January 30, 2026

**Re: Ellison Warehouse**  
**4000 Ellison St NE**  
**30-Day Temporary Certificate of Occupancy**  
**Transportation Development Final Inspection**  
Architect's Stamp dated 05-09-22 (D17-D074)  
Certification dated 01-28-2026  
TRANS-2026-00023

Based upon the information provided in your submittal received 01-26-26, Transportation Development has no objection to a 30-day Temporary Certificate of Occupancy based. This letter serves as a "green tag" from Transportation Development for a 30-day Temporary Certificate of Occupancy to be issued by the Building and Safety Division.

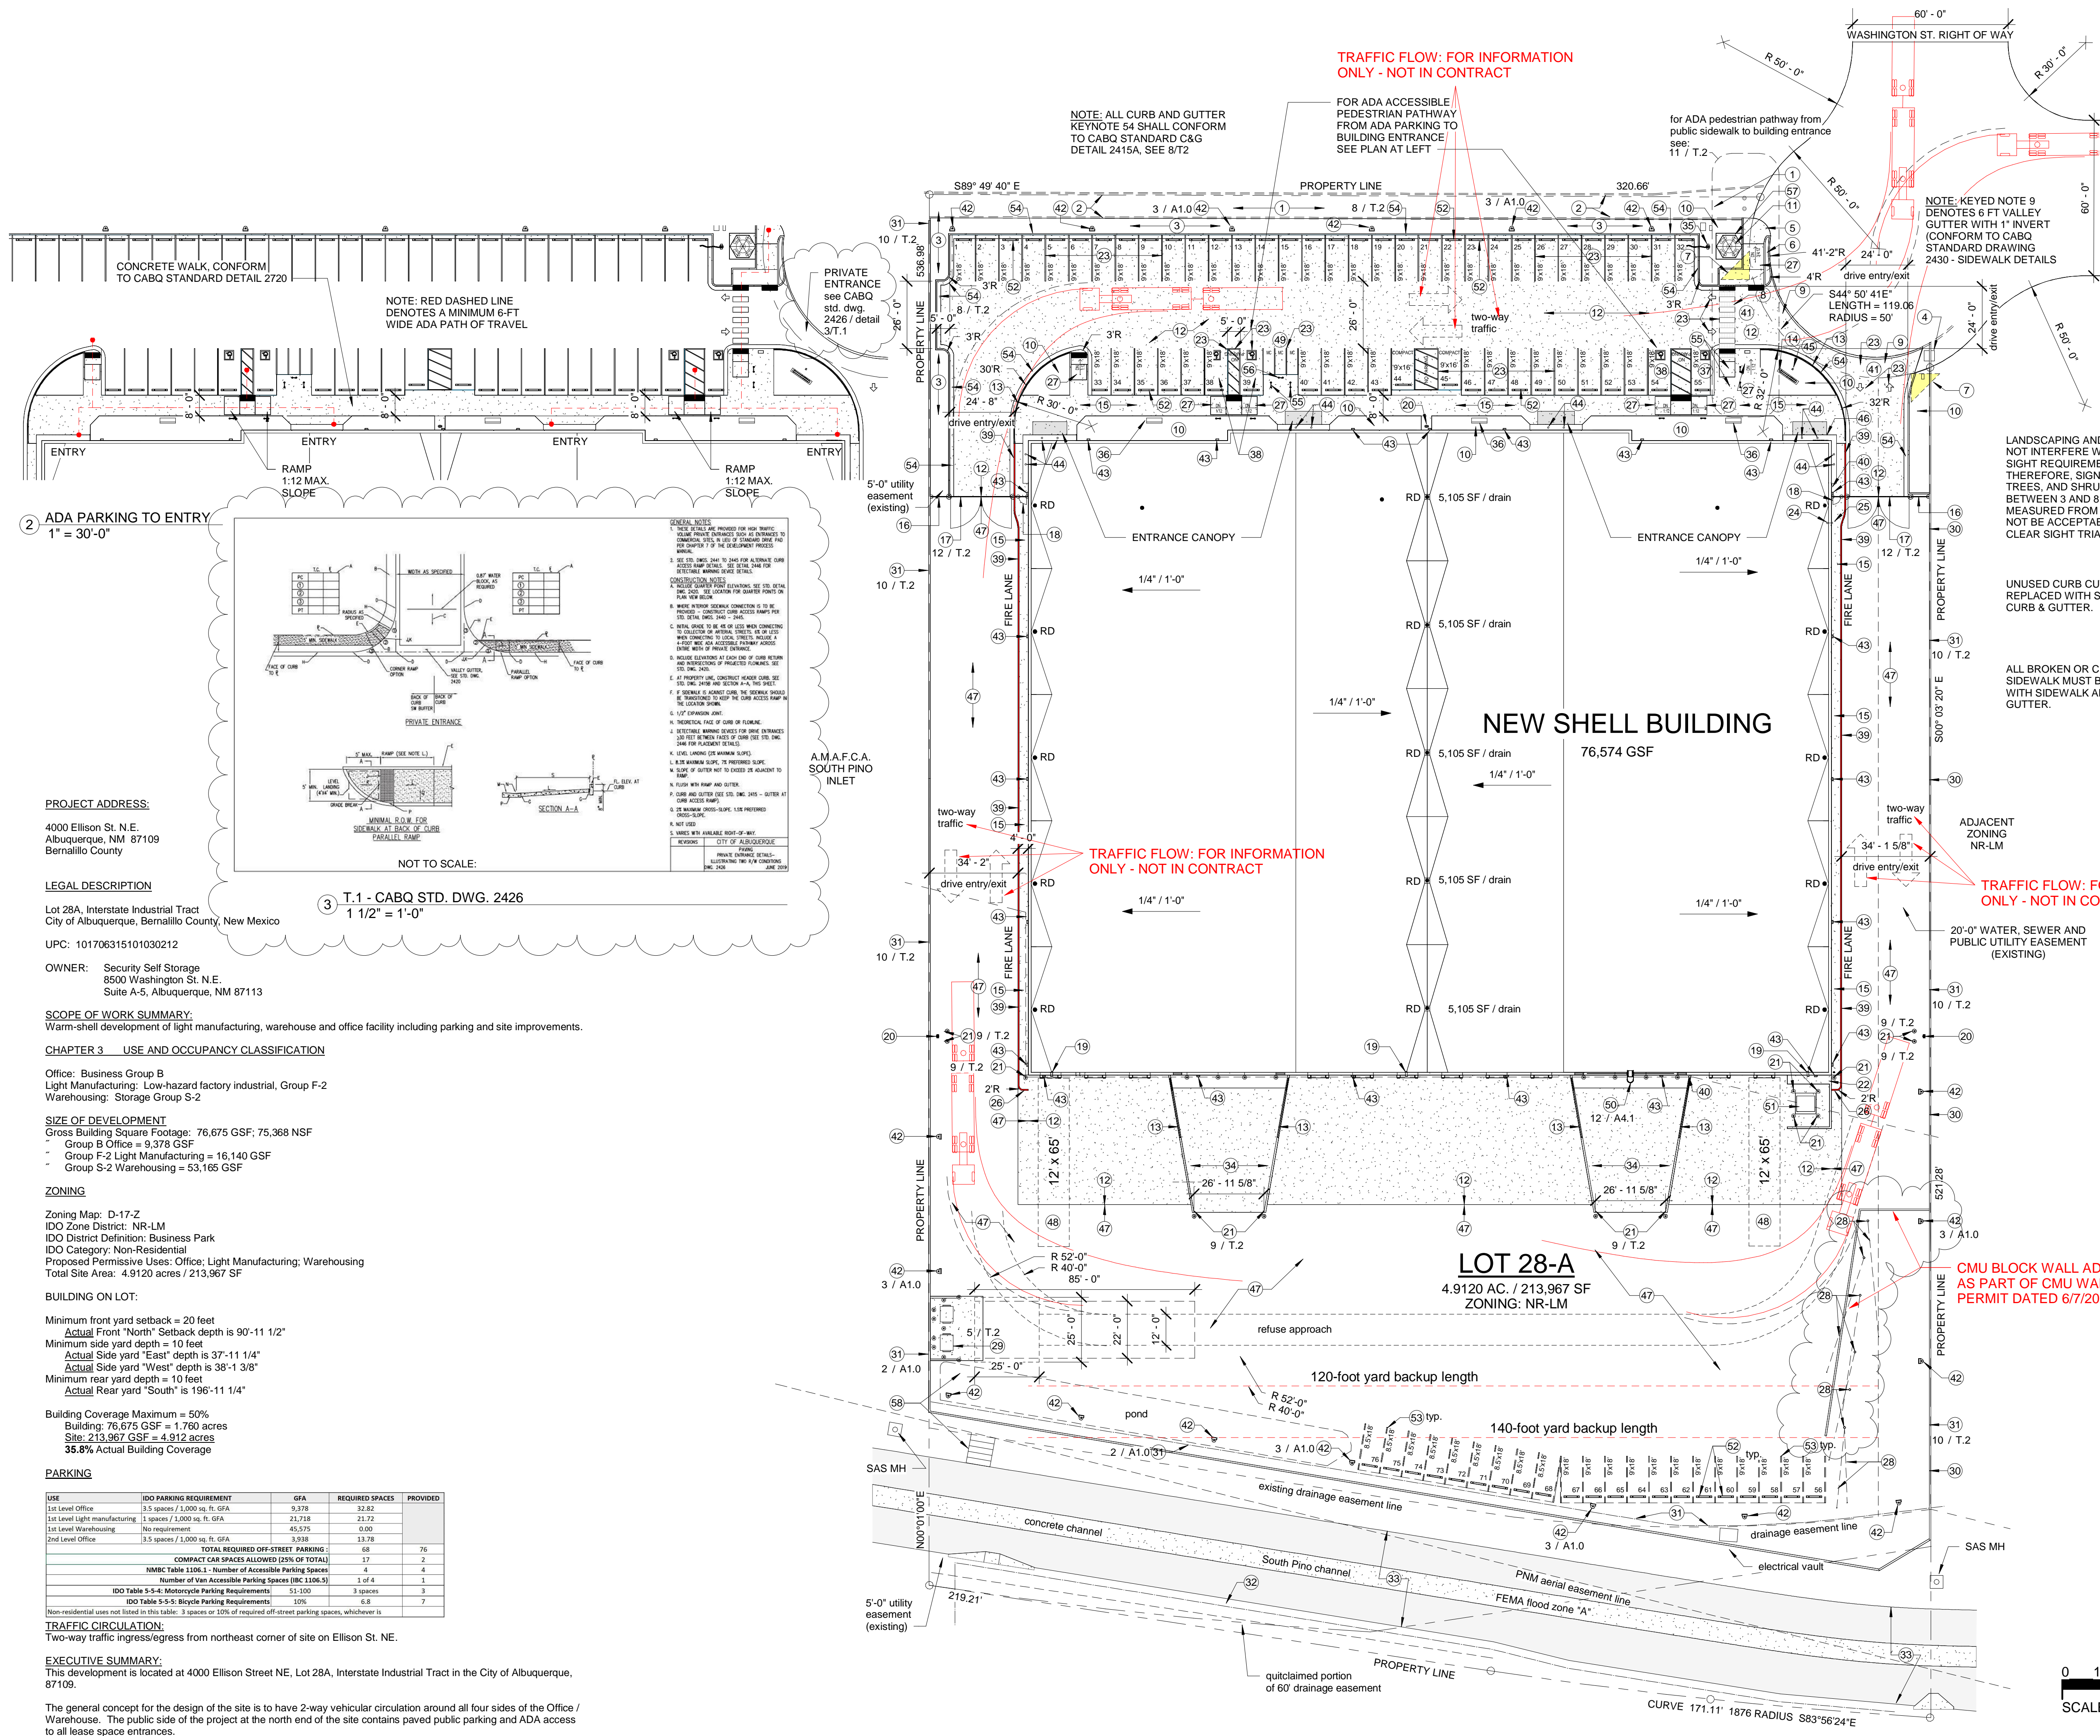
- A sidewalk easement will be needed prior to Certificate of Occupancy to incorporate the ADA pathway with a maximum 2% cross-slope along frontage of property.

Once this correction is complete, email the sidewalk easement to [malnajjar@cabq.gov](mailto:malnajjar@cabq.gov) for release of Final CO.
